June 24, 2026

Re: Trinity Ranch CS Rezone - Traffic Impact Study CDOT 2nd Review Response Letter
SH-94 and Peyton Highway
El Paso County, Colorado

FIGURE 15
Trinity Ranch
El Paso County, CO
2030 Recommended Geometry and Control

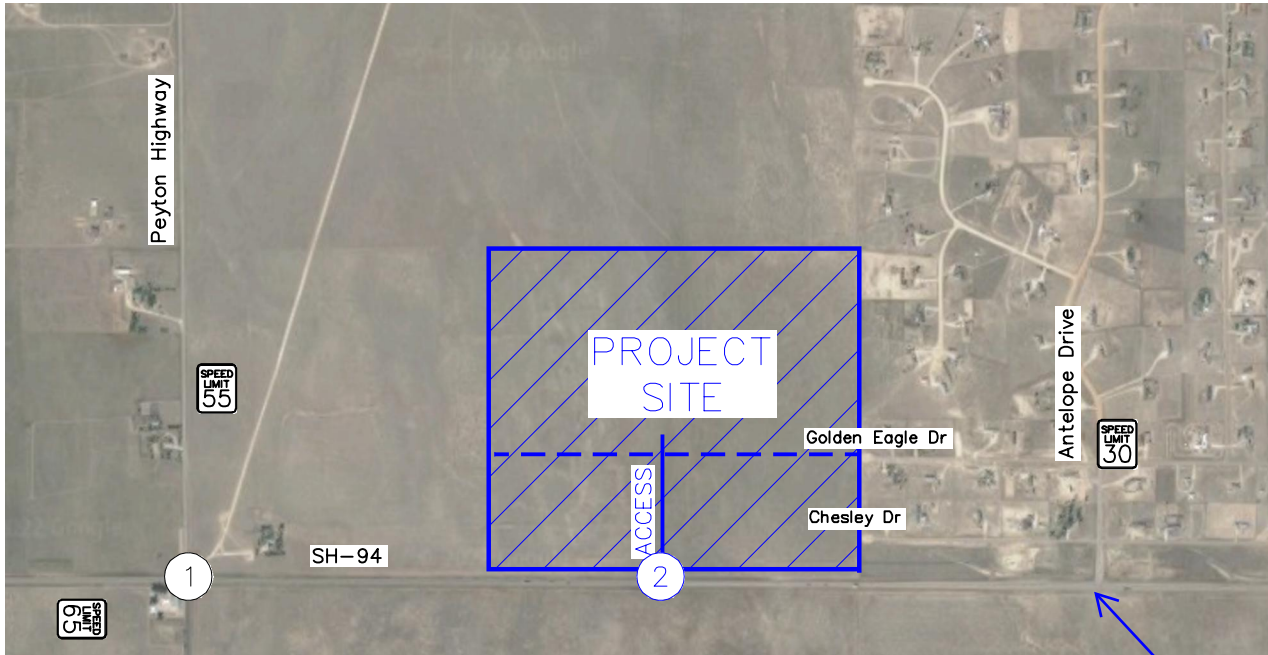
Traffic Comment #1: An eastbound left turn lane is warranted at the CO-94 Access intersection based on projected 2050 background plus project traffic volumes being 31 eastbound left turns during the peak hour and the threshold being 10 vph. Based on the 65 mile per hour speed limit, the deceleration length is 500 feet, plus a 300-foot taper. In addition, a 30-foot storage length is required based on the peak hour left turn entering volume. Therefore, the eastbound left turn lane is recommended to provide a length of 530 feet plus a 300-foot taper to meet CDOT turn lane standards.

Response: Comment acknowledged, the traffic study will continue to recommend this left turn lane and the associated lengths.
